Application Ref:	3/2021/0178	 <div>Ribble Valley Borough Council</div> <div>www.ribblevalley.gov.uk</div>	
Date Inspected:	N/A		
Officer:	BT		
DELEGATED ITEM FILE REPORT:		Decision	Approval

Development Description:	Removal of existing conservatory and construction of a replacement rear extension.
Site Address/Location:	12 The Crescent, Whalley, Lancashire. BB7 9JW

Drawing No.	TC-01	REV	A
-------------	-------	-----	---

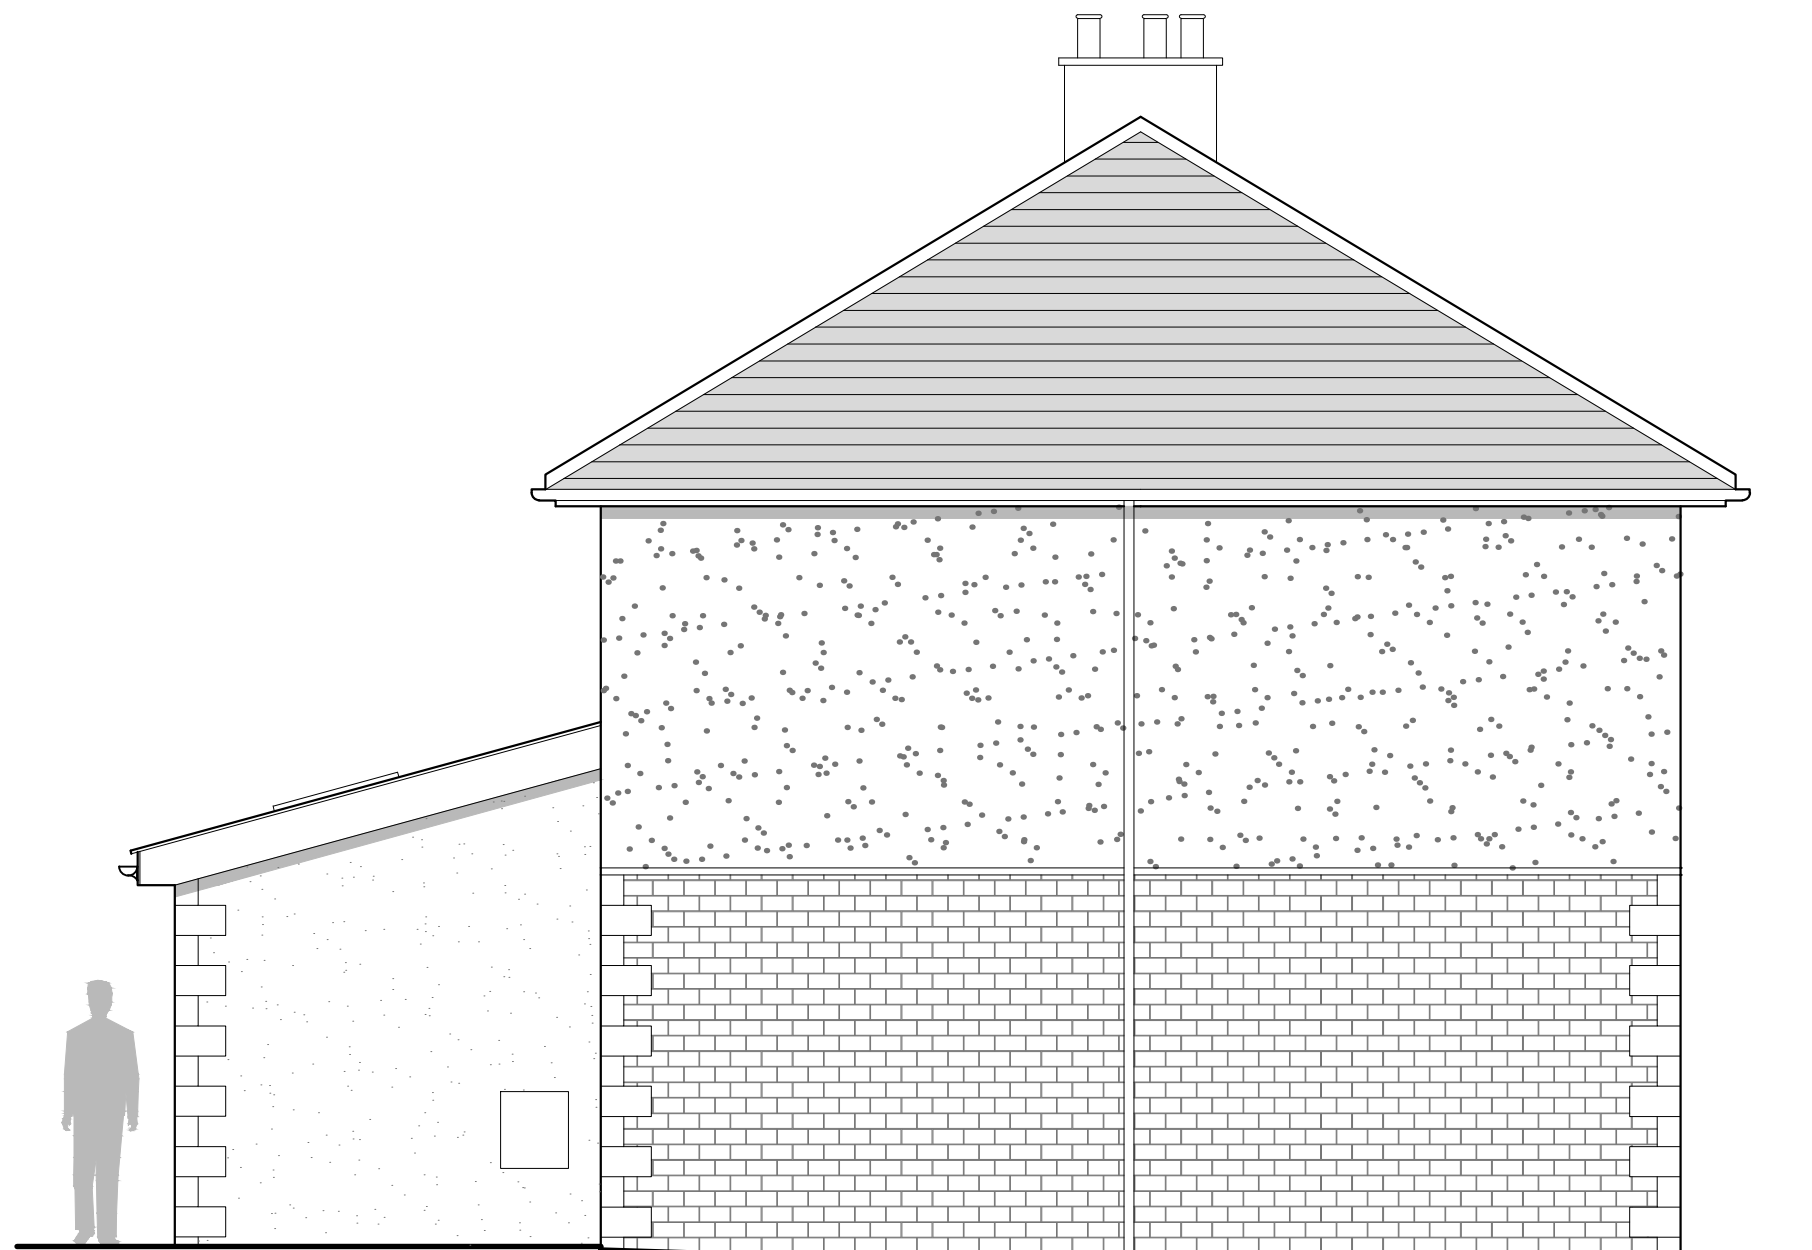
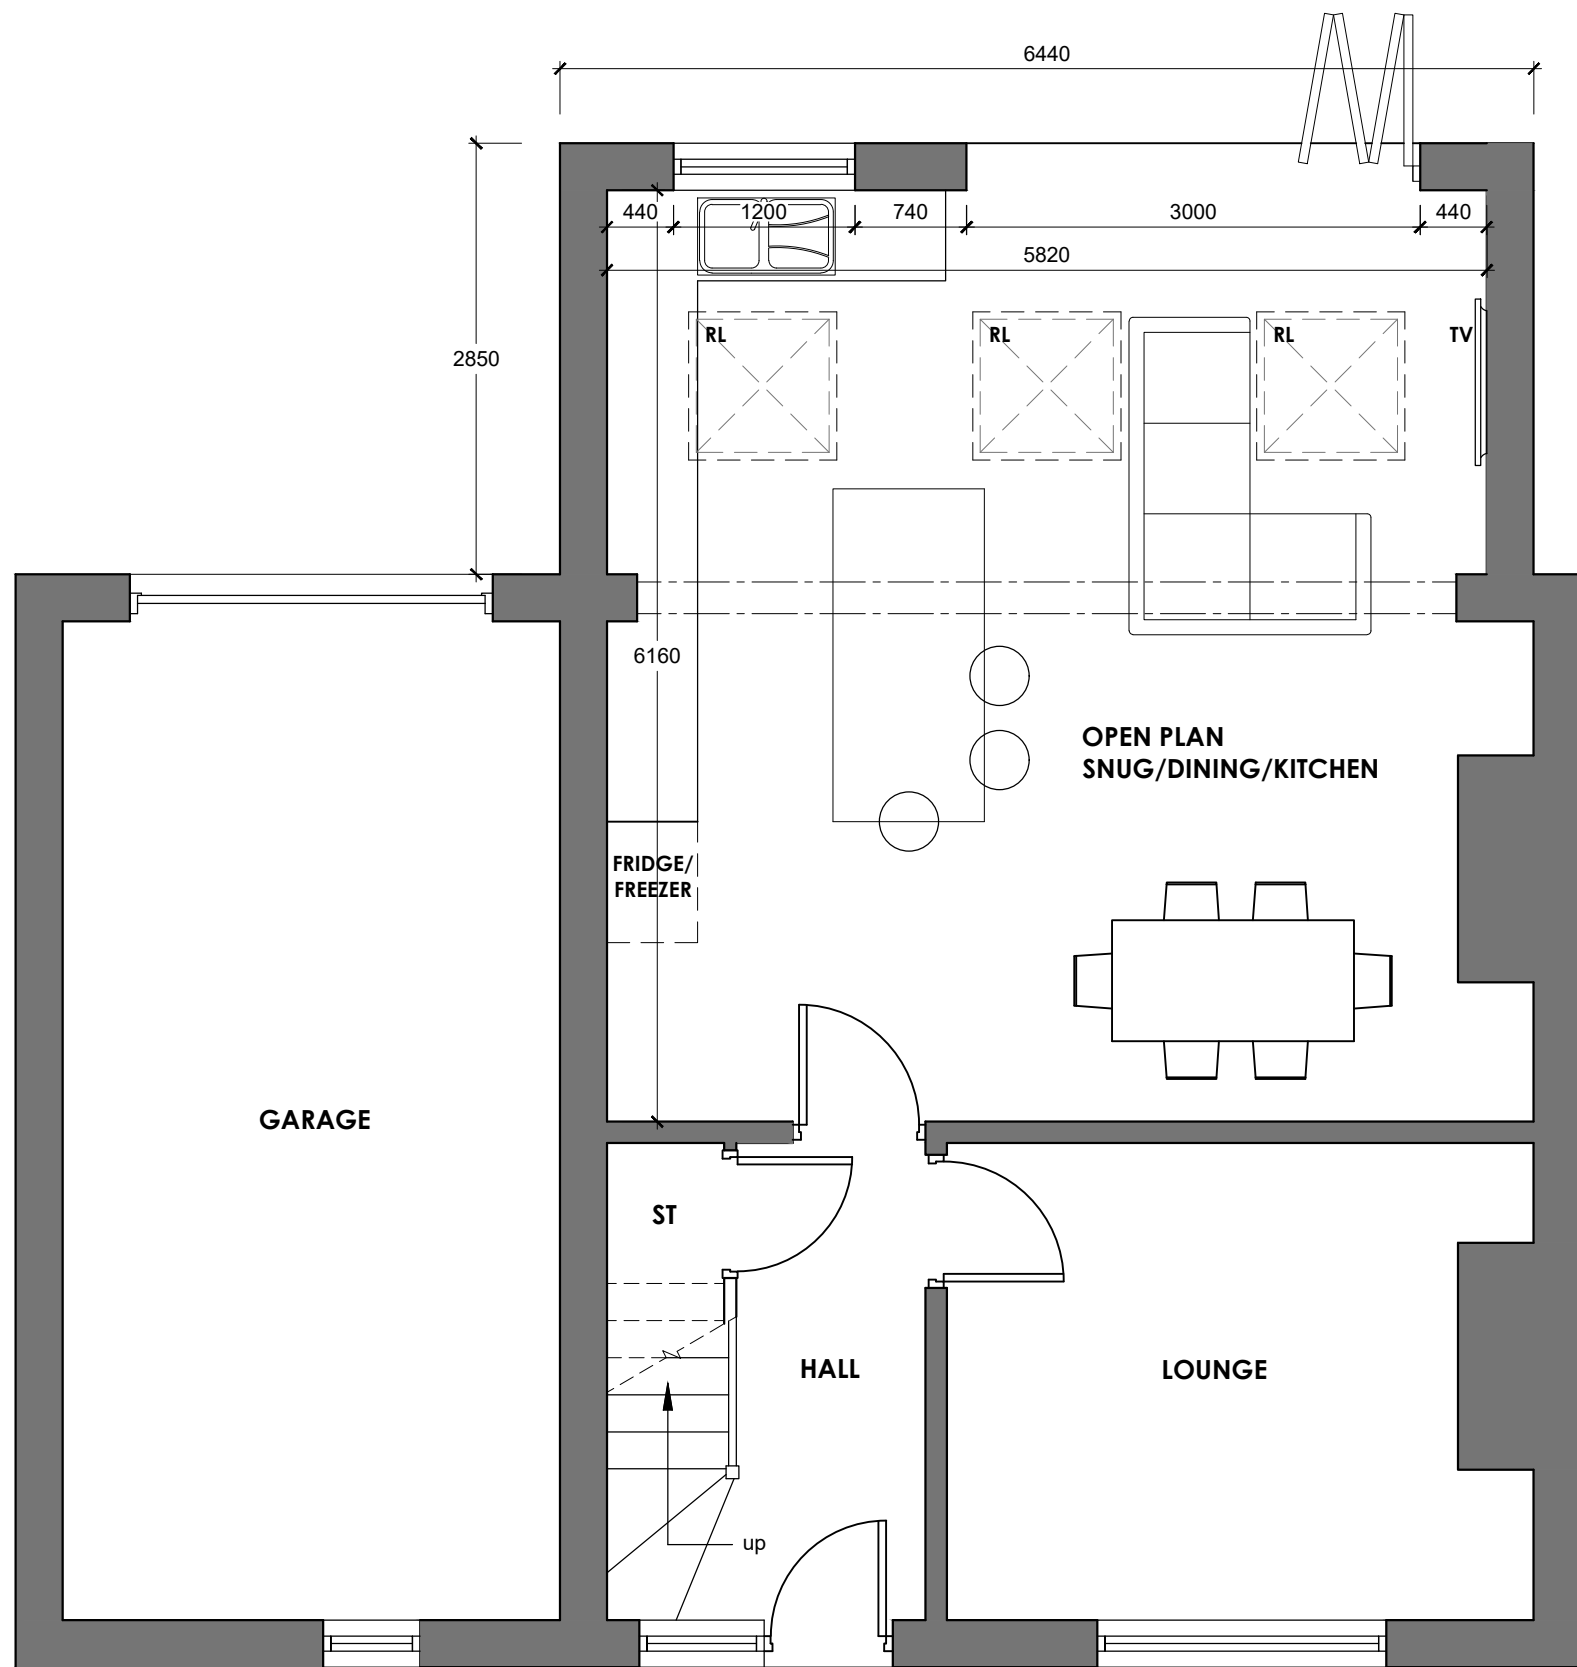
The height of the proposed single storey extension would not exceed the height of the existing dwelling.

The height of the eaves of the proposed extension would not exceed the height of the eaves of the existing dwellinghouse.

The proposed single storey extension would extend beyond the rear wall of the original dwellinghouse by 2.8 metres and measure 3.5 metres in height.

The proposed single storey extension would be within 2 metres of the boundary of the curtilage of the dwellinghouse and would be 2.4 metres in height to the eaves measured from the highest part of the surface of the ground adjacent to it.
